Our Ref: BR/20/18/PL
Your Ref:

Town & Country Planning Act 1990 (as amended)
Town and Country Planning (Development Management Procedure) (England) Order 2015
Application for Planning Permission

Development Change of use of shingle beach opposite the kiosk for the installation of decking with a wooden windbreak to form a seating area.

Location Shingle beach outside Coffee Cup Kiosk Bognor Regis Esplanade Bognor Regis

Block Plan shows area bounded by: 493976.91, 98958.61 494012.91, 98994.61 (at a scale of 1:200) The representation of a road, track or path is no evidence of a right of way. The representation of features as lines is no evidence of a property boundary.

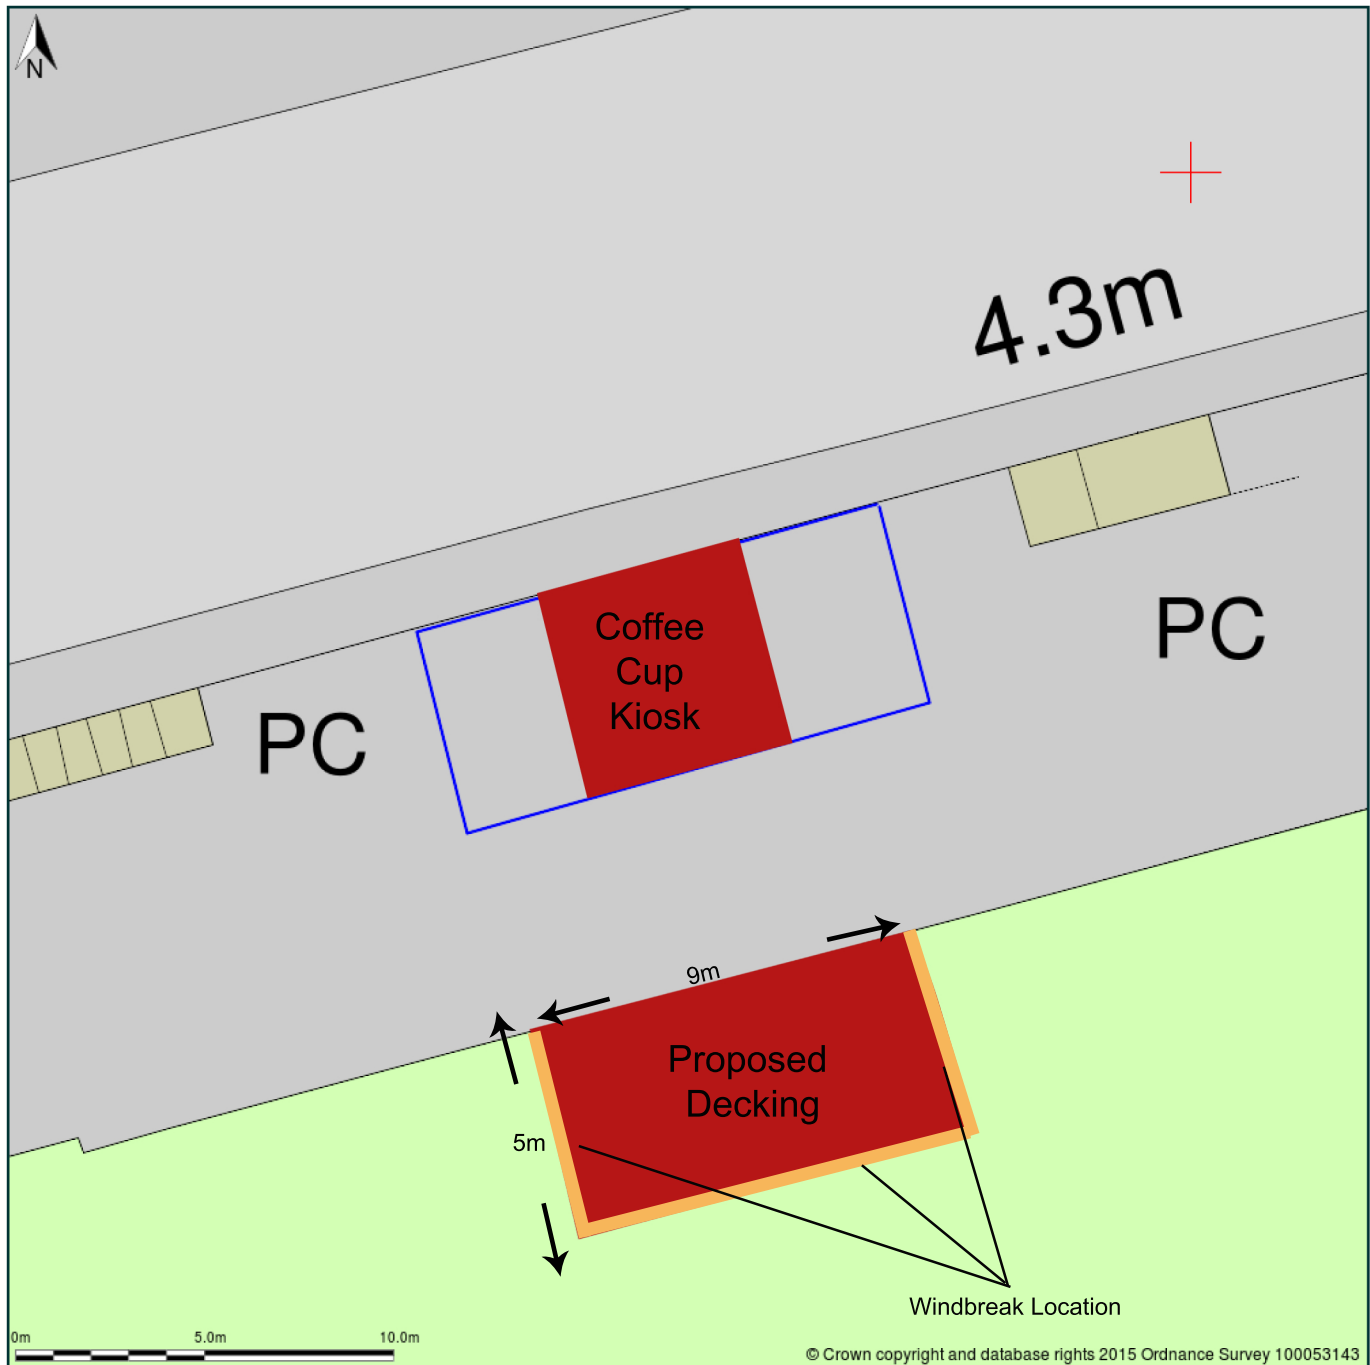
Block Plan - Amend

Please submit 1 electronic or 3 paper copies of an amended block/site plan at a scale of 1:500 or 1:200 to include the position of the proposed windbreak shown on the decking. Further details of what must be included on the plan can be found in the National Validation Requirements.

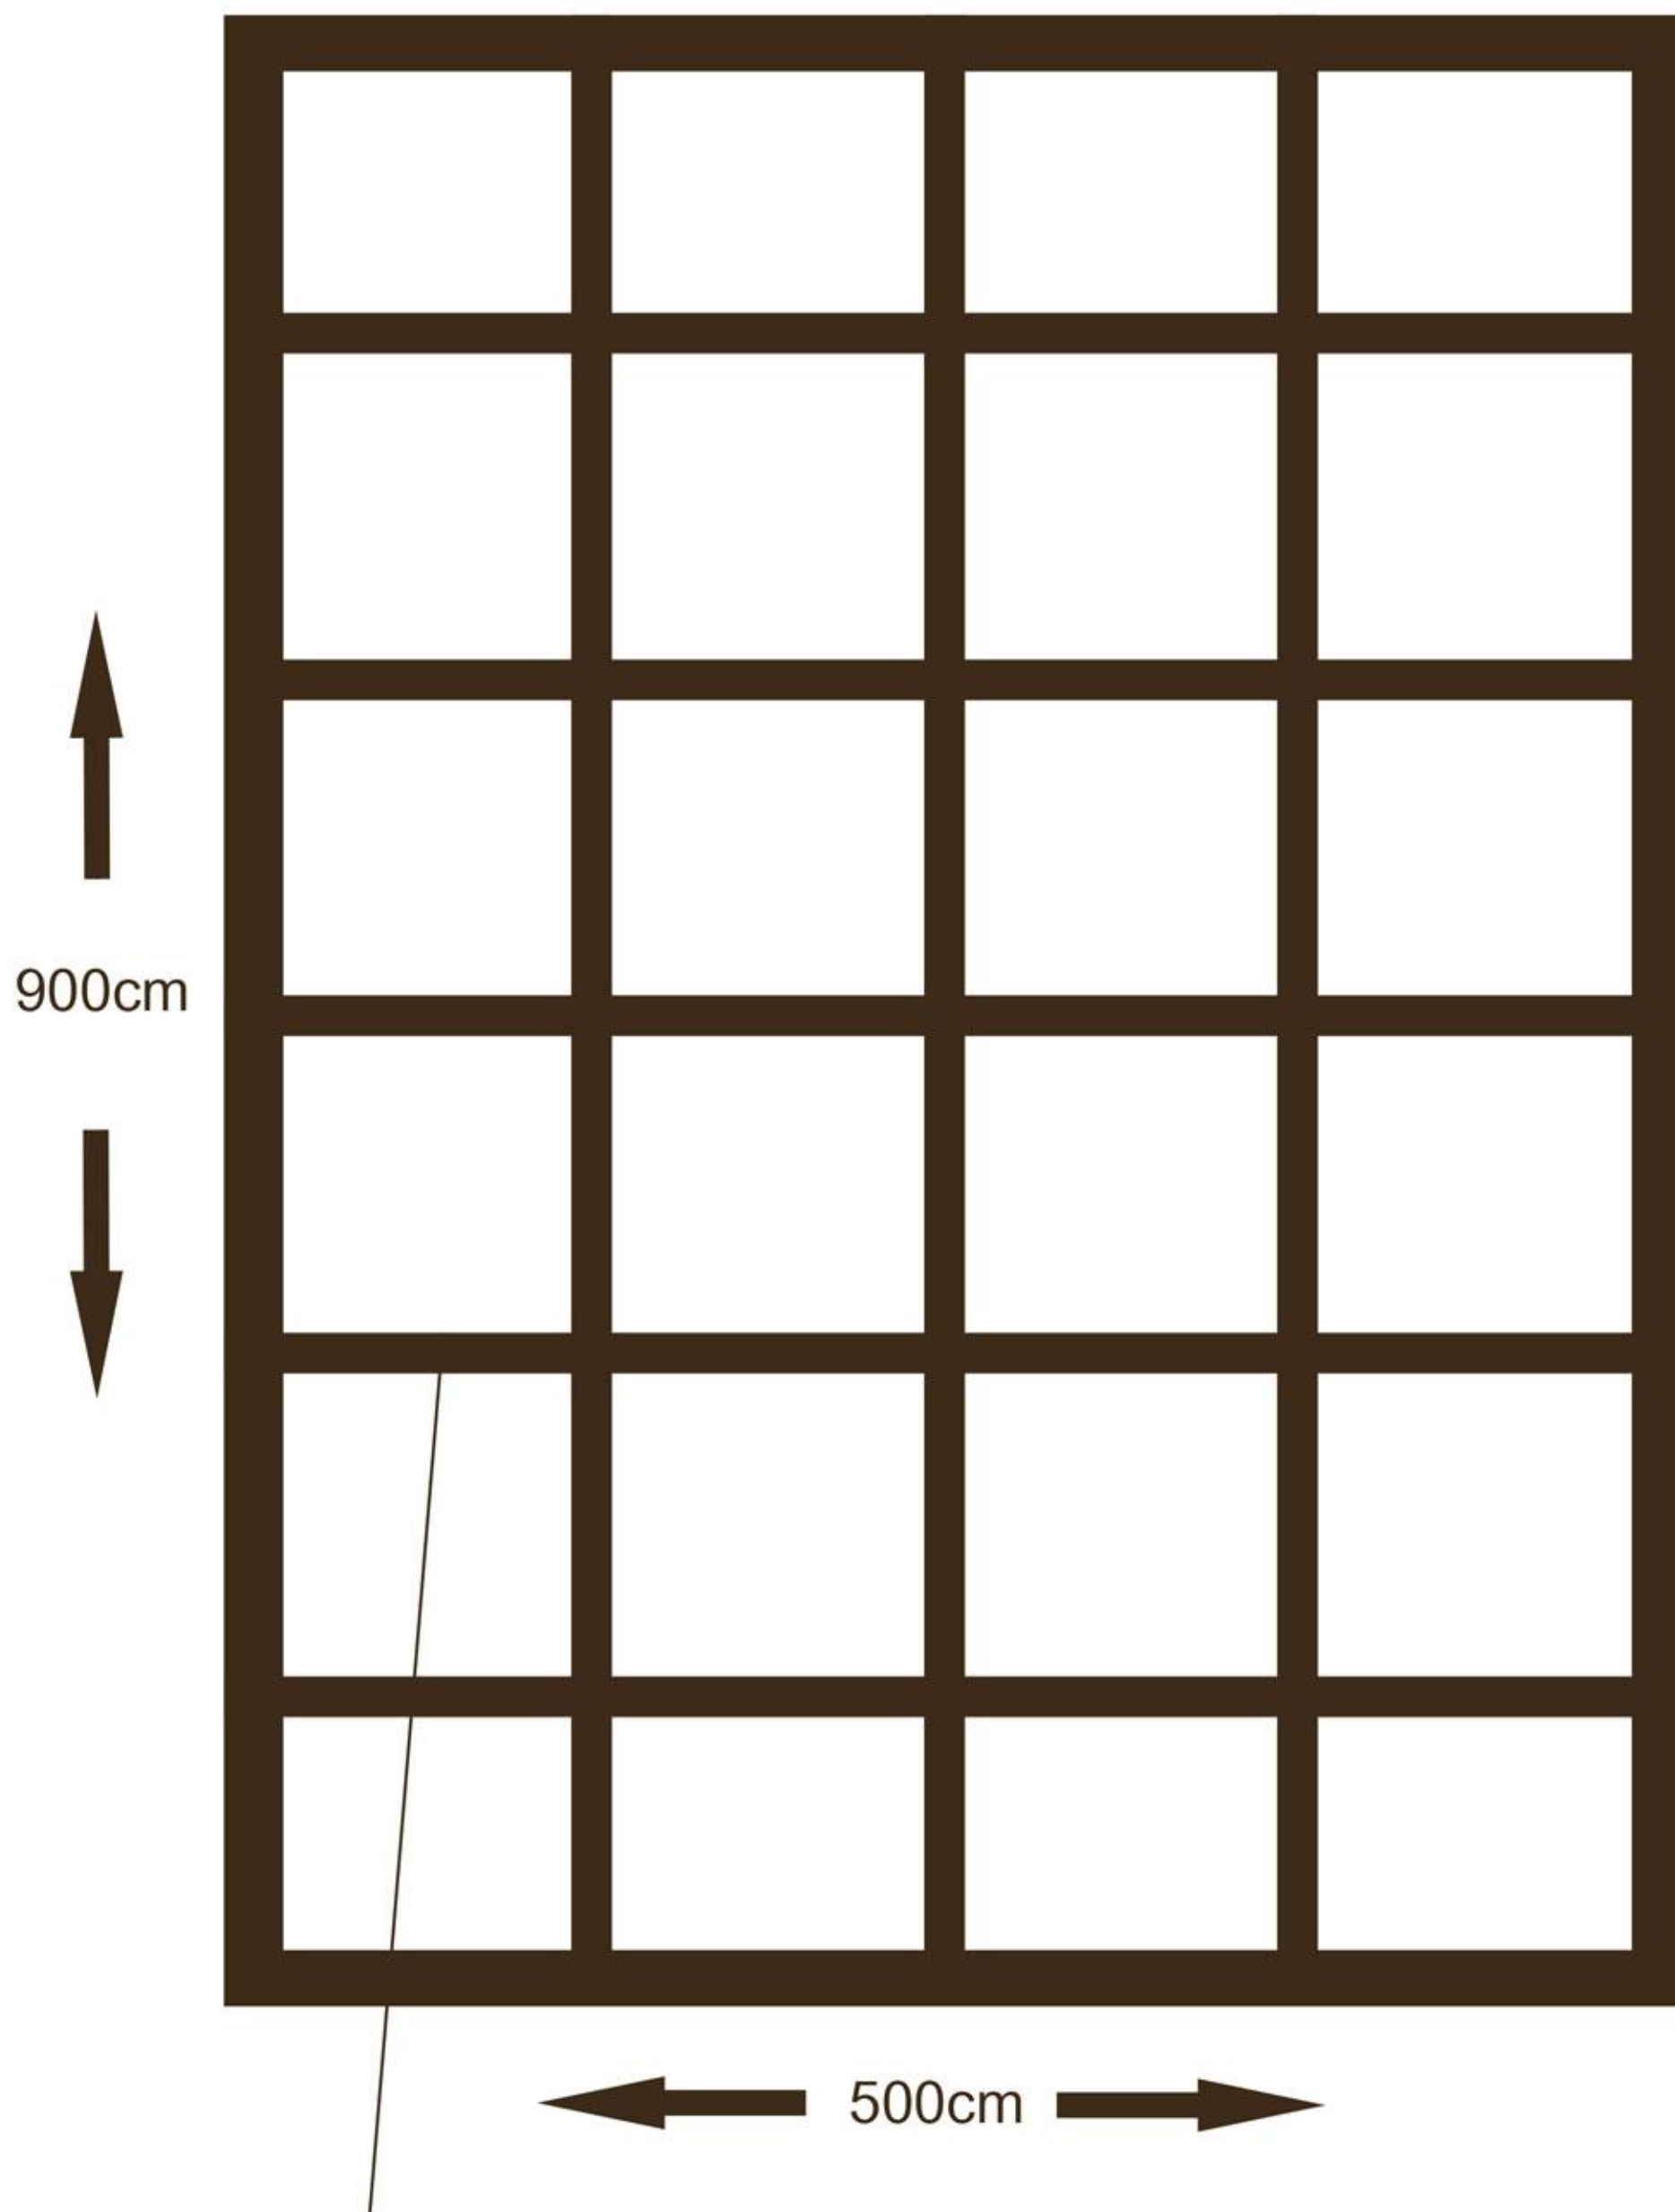
Sections

Please submit 1 electronic or 3 paper copies of a sectional plan of the proposed decking structure and finished floor/site levels to show the height and design. Further details can be found in the National Validation Requirements.
